Online Comment

Application H09-0523-20
Location Land off Damgate Holbeach Spalding
Proposal Details of Conditions 3, 4, 5, 6, 7, 8, 9, 10, 11, 13, 14, 15, 16, 17, 18, 19, 20, 21, 22 and 23 H09-0332-16

Name Sue Armour
Address Environmental Protection Officer SHDC PE11 2XE

Date Submitted 05-08-20
For/Against Comments

DRAWING: Gas Membrane Details

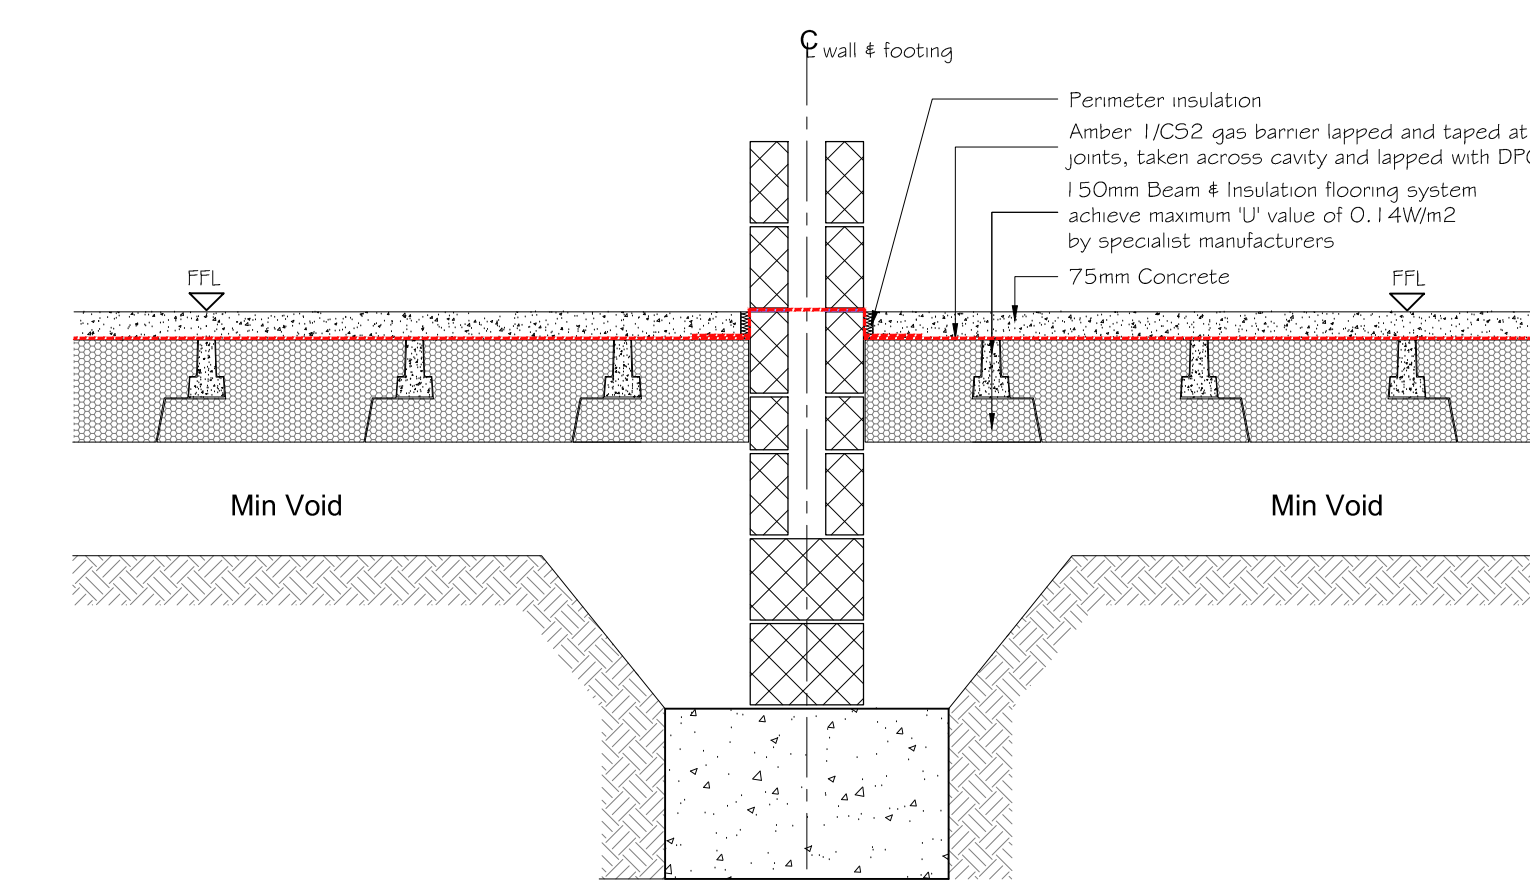
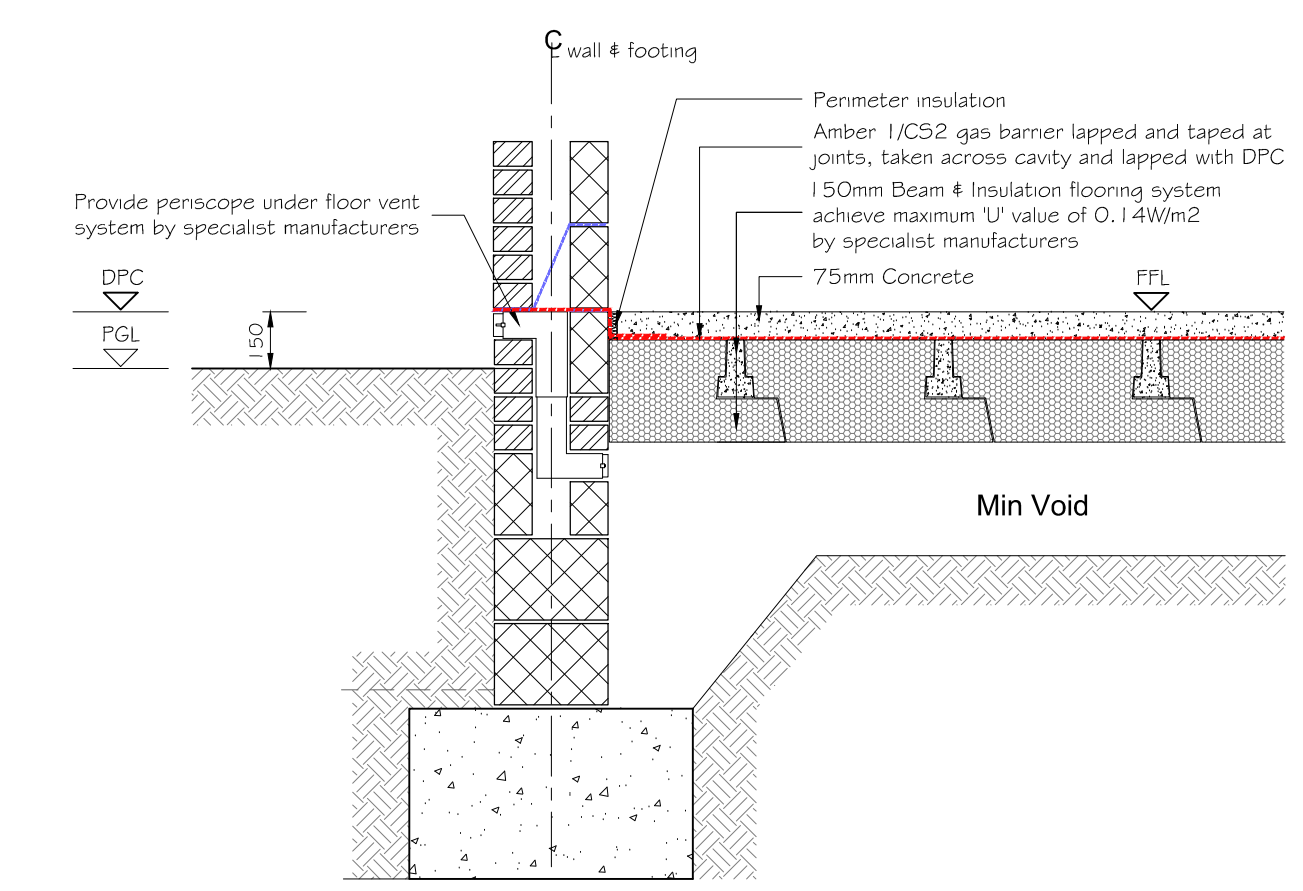
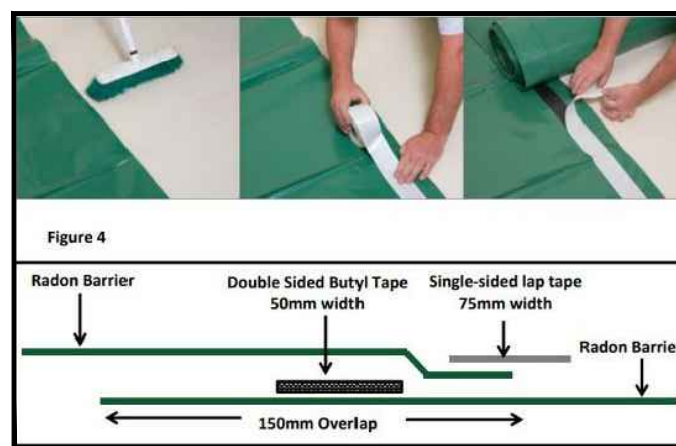
The report currently recommends either installation of ground gas protection measures to CS2 or further monitoring to delineate the area of which these may be required. Either option is acceptable.

I look forward to receipt of a remediation method statement, containing detailed proposals for both items, in due course.
